**Deadline 7a** (24 May 2019) – KCC’s response to the ExA’s Third Written Questions

ANNEX 4
OFF-SITE JUNCTIONS PLAN

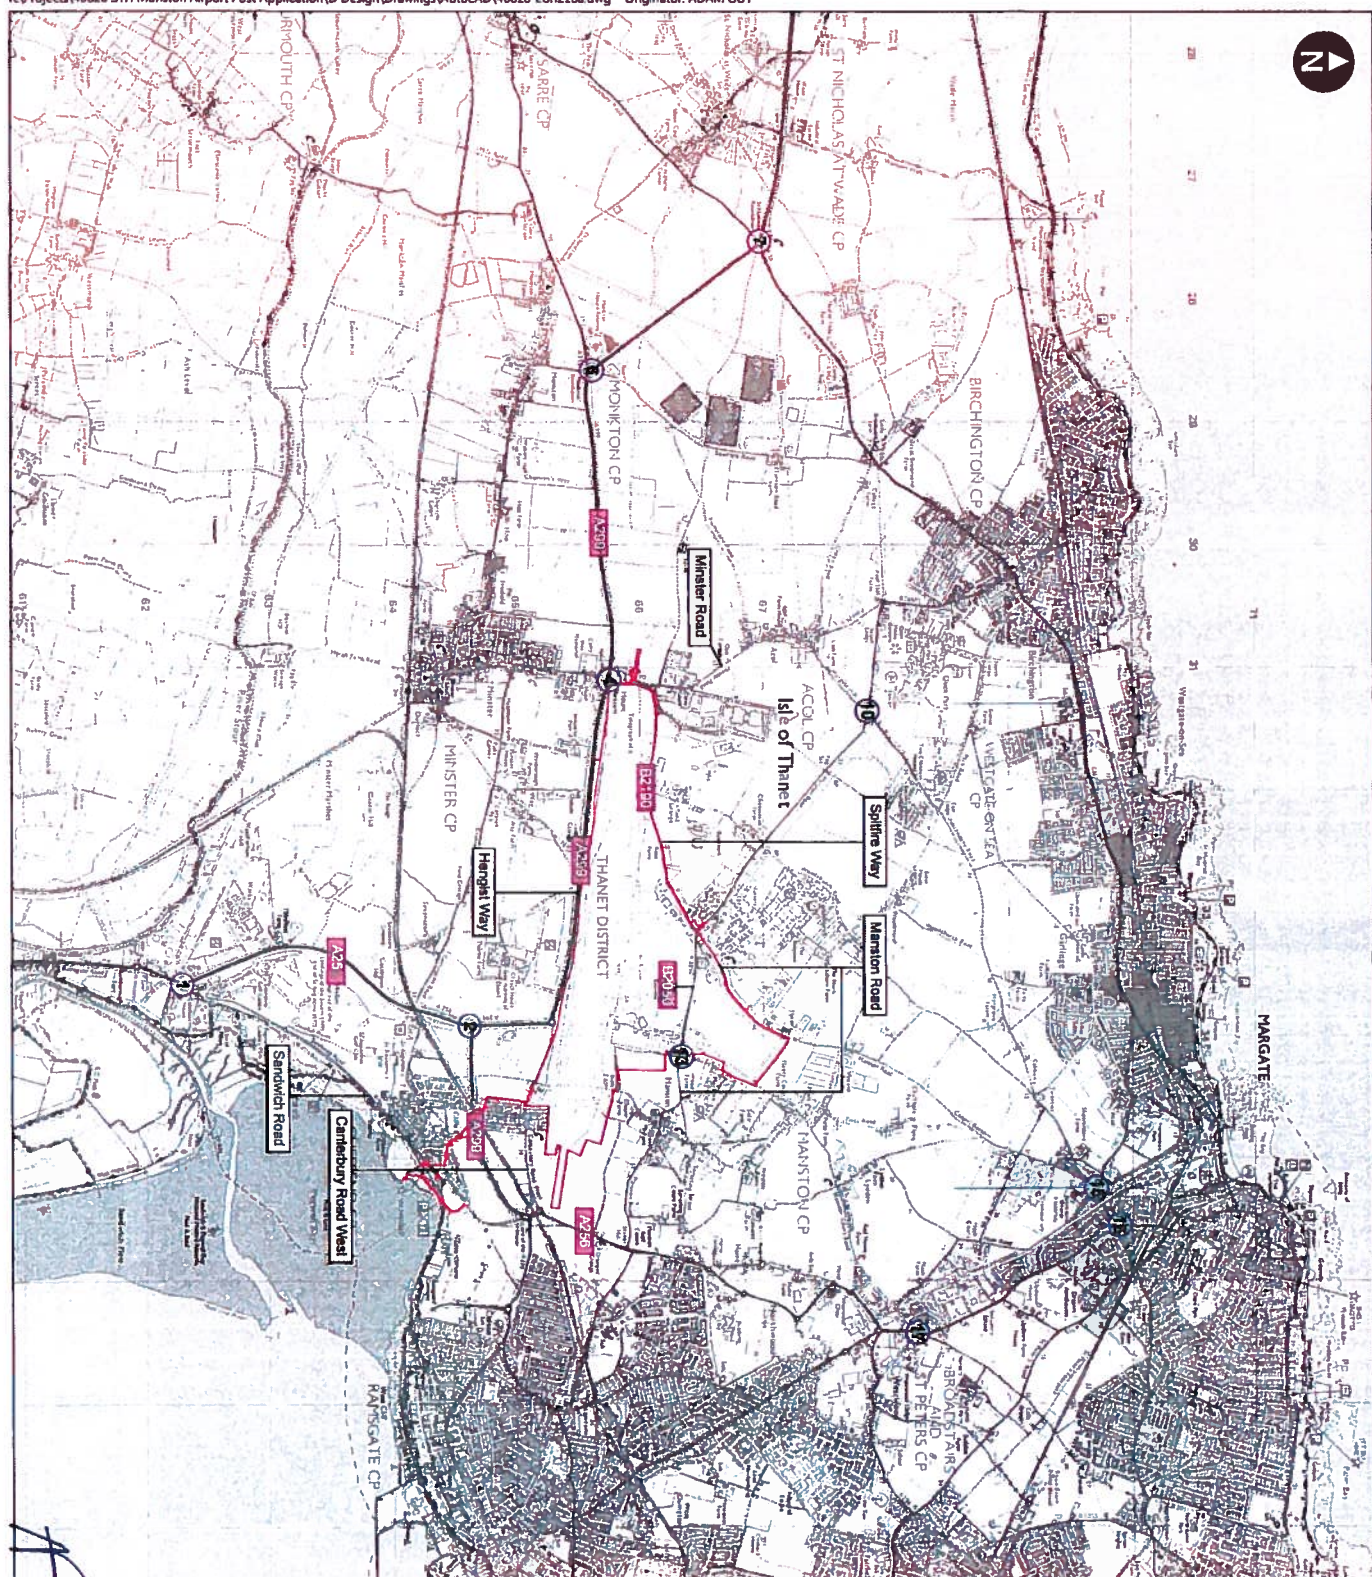
TR.3.24	<p>Junction 2  KCC’s response to second written question Tr.2.37 [REP6-index number to be allocated] states:  <i>“Whilst the Applicant’s response to KCC’s LIR is accepted in respect to lane markings, it is noted that the Applicant proposes a right pointing arrow on the eastbound approach to the proposed cargo facility access roundabout, which should be removed on this basis.”</i>  i. Does the Applicant agree?  The appendices supporting the Applicant’s response to Second Written Questions at Appendix Tr.2.57 [REP6-index number to be allocated] includes a Stage 1 Safety Audit of the junction.  ii. Is KCC content with its findings and the design response?  iii. Can the recommendations be suitably addressed and delivered during the detailed design stage?</p>	<p>i) KCC is not satisfied with the Designer’s Response, in that the requested swept path analysis for HGVs has not been provided to address the Auditor’s request. It is noted in this respect that KCC has previously requested swept path analysis drawings of this mitigation scheme on at least two previous occasions, primarily due to concerns regarding the potential for collisions between circulating vehicles on the roundabout gyratory. Indeed, this concern is identified separately by the Auditor.  ii) The above issue is not considered capable of being addressed at the detailed design stage, as it may require a significant revision of the mitigation scheme, potentially requiring land outside of the existing highway boundary.</p>

TR.3.25	<p>Junction 4  The appendices supporting the Applicant’s response to Second Written Questions at Appendix Tr.2.57 [REP6-index number to be allocated] includes a Stage 1 Safety Audit of the junction.  i. Is KCC content with its findings and the design response?  ii. Can the recommendations be suitably addressed and delivered during the detailed design stage?</p>	<p>i) KCC is not satisfied with the Designer’s Response, in that the requested swept path analysis for HGVs has not been provided to address the Auditor’s request. It is noted in this respect that KCC has previously requested swept path analysis drawings of this mitigation scheme on at least two previous occasions, primarily due to concerns regarding the potential for collisions between circulating vehicles on the roundabout gyratory.  ii) The above issue is not considered capable of being addressed at the detailed design stage, as it may require a significant revision of the mitigation scheme, potentially requiring land outside of the existing highway boundary.</p>

TR.3.26	<p>Junction 6  The appendices supporting the Applicant’s response to Second Written Questions at Appendix Tr.2.57 [REP6-index number to be allocated] includes a Stage 1 Safety Audit of the junction.  i. Is KCC content with its findings and the design response?  ii. Can the recommendations be suitably addressed and delivered during the detailed design stage?</p>	<p>i) KCC is not satisfied with the Designer’s Response, in that the requested swept path analysis for HGVs has not been provided to address the Auditor’s request. It is noted in this respect that KCC has previously requested swept path analysis drawings of this mitigation scheme on at least two previous occasions, primarily due to concerns regarding the potential for collisions between circulating vehicles on the roundabout gyratory. Indeed, this concern is identified separately by the Auditor.  ii) The above issue is not considered capable of being addressed at the detailed design stage, as it may require a significant revision of the mitigation scheme, potentially requiring land outside of the highway boundary.</p>

TR.3.27	<p>Junction 7  The appendices supporting the Applicant’s response to Second Written Questions at Appendix Tr.2.57 [REP6-index number to be allocated] includes a Stage 1 Safety Audit of the junction.  i. Is KCC content with its findings and the design response?  ii. Can the recommendations be suitably addressed and delivered during the detailed design stage?</p>	<p>There is a concern with a potential increased likelihood of side swipe collisions at this roundabout. The proposal for vehicles travelling between the A299 (west) approach and the A299 (south-east) exit to use either lane on the roundabout circulatory has the potential to cause collisions with vehicles making opposing manoeuvres (e.g. from the A299 (south-east) approach to the A28 (north-east) exit), whose drivers may not appreciate that they intend to continue past their exit. Therefore, KCC is not content with the findings of the Safety Audit.</p>

<p>TR.3.28</p>	<p>Junction 12</p> <p>KCC’s response to second written question Tr.2.41 [REP6-index number to be allocated] states:  <i>“ii. It is noted that the inter-visibility splay between the Manston Road (north) and Manston Road (west) arms of the signalised junction layout falls outside of the highway boundary, which presents a highway safety risk. KCC would also reiterate its previous concern regarding the incorporation of uncontrolled right turns within the junction intersection. The alternative roundabout layout is therefore preferred by KCC and will maintain route consistency as the junctions between Haine Road and A299 (Via Spitfire way) predominantly consist of roundabouts.</i>  <i>iii. Both potential mitigation schemes (Signal and Roundabout) would have an impact on the footprint of the RAF Museum.”</i></p> <p>i. What is the Applicant’s response?  ii. Does the Applicant accept that the inter-visibility splay falls outside of the highway boundary?  iii. If so, how can this be overcome?  iv. How will the impact on the footprint of the RAF Museum building (as shown on Figure 7.5 of the RTA [REP5-021]) be addressed?  v. Why does KCC believe that the incorporation of uncontrolled right turns within the junction intersection would result in highway safety concerns?</p> <p>The appendices supporting the Applicant’s response to Second Written Questions at Appendix Tr.2.57 [REP6-index number to be allocated] includes a Stage 1 Safety Audit of the junction.</p> <p>vi. Is KCC content with its findings and the design response?  vii. Can the recommendations be suitably addressed and delivered during the detailed design stage?</p>	<p>vi) The incorporation of uncontrolled right turns within the junction intersection could result in forward visibility for right turning drivers becoming obstructed by vehicles making the opposing right turn, with the potential for collisions with oncoming traffic. This risk is considered particularly significant in relation to vehicles turning right from the B2050 Manston Road (north) into Spitfire Way, due to the curvature of the road. KCC is concerned that neither this issue nor the issue of the inter-visibility splay between Manston Road (north) and Manston Road (west) crossing third party land have been identified by the Road Safety Audit.</p> <p>KCC is not satisfied with the Safety Audit or Designer’s Response for the above reasons. Moreover, the requested swept path analysis for HGVs has not been provided to address the Auditor’s request.</p> <p>vii) The above issues are not considered capable of being addressed at the detailed design stage, as they may require a significant revision of the mitigation scheme, potentially requiring land outside of the highway boundary.</p>

<p>TR.3.29</p>	<p>Junction 15</p> <p>KCC’s response to second written question Tr.2.42 [REP6-index number to be allocated] states:  <i>“The Applicant’s proposed scheme of mitigation results in significantly increased queue lengths on the College Road approach to the junction relative to the baseline (with Local Plan) scenario. This would cause interaction with the Ramsgate Road / College Road / A254 / Beatrice Road junction to the north, which is unacceptable to KCC.</i>  <i>It is also relevant to note that this mitigation solution could not be implemented until other development sites were delivered as it relies on other road link infrastructure being in place to enable the Nash Road arm of this junction to be closed as traffic will need to reroute between Nash Road and Manston Road.”</i></p> <p>i. What is the Applicant’s response?</p> <p>The appendices supporting the Applicant’s response to Second Written Questions at Appendix Tr.2.57 [REP6-index number to be allocated] includes a Stage 1 Safety Audit of the junction.</p> <p>ii. Is KCC content with its findings and the design response?  iii. Can the recommendations be suitably addressed and delivered during the detailed design stage?</p>	<p>ii) KCC is not satisfied with the Designer’s Response, in that the requested swept path analysis for HGVs has not been provided to address the Auditor’s request.</p> <p>iii) The above issue is not considered capable of being addressed at the detailed design stage, as it may require a significant revision of the mitigation scheme, potentially requiring land outside of the highway boundary.</p>

<p>TR.3.30</p>	<p>Junction 16</p> <p>KCC’s response to second written question Tr.2.43 [REP6-index number to be allocated] states:  <i>“...the proposed mitigation for the Ramsgate Road / College Road / A254 / Beatrice Road junction would appear to result in a highly unconventional junction layout, which is unlikely to be acceptable to KCC, not least due to the lack of intervisibility between the stop lines.”</i></p> <p>i. What is the Applicant’s response?</p> <p>The appendices supporting the Applicant’s response to Second Written Questions at Appendix Tr.2.57 [REP6-index number to be allocated] include a Stage 1 Safety Audit of the junction.</p> <p>ii. Is KCC content with its findings and the design response?  iii. Can the recommendations be suitably addressed and delivered during the detailed design stage?</p>	<p>ii) KCC is not content with the findings of the Safety Audit, in that it has not identified the unconventional nature of the proposed junction layout and the lack of intervisibility between stop lines as potential hazards.</p> <p>iii) The above issues are not considered capable of being addressed at the detailed design stage, as they may require a significant revision of the mitigation scheme, potentially requiring land outside of the highway boundary.</p>
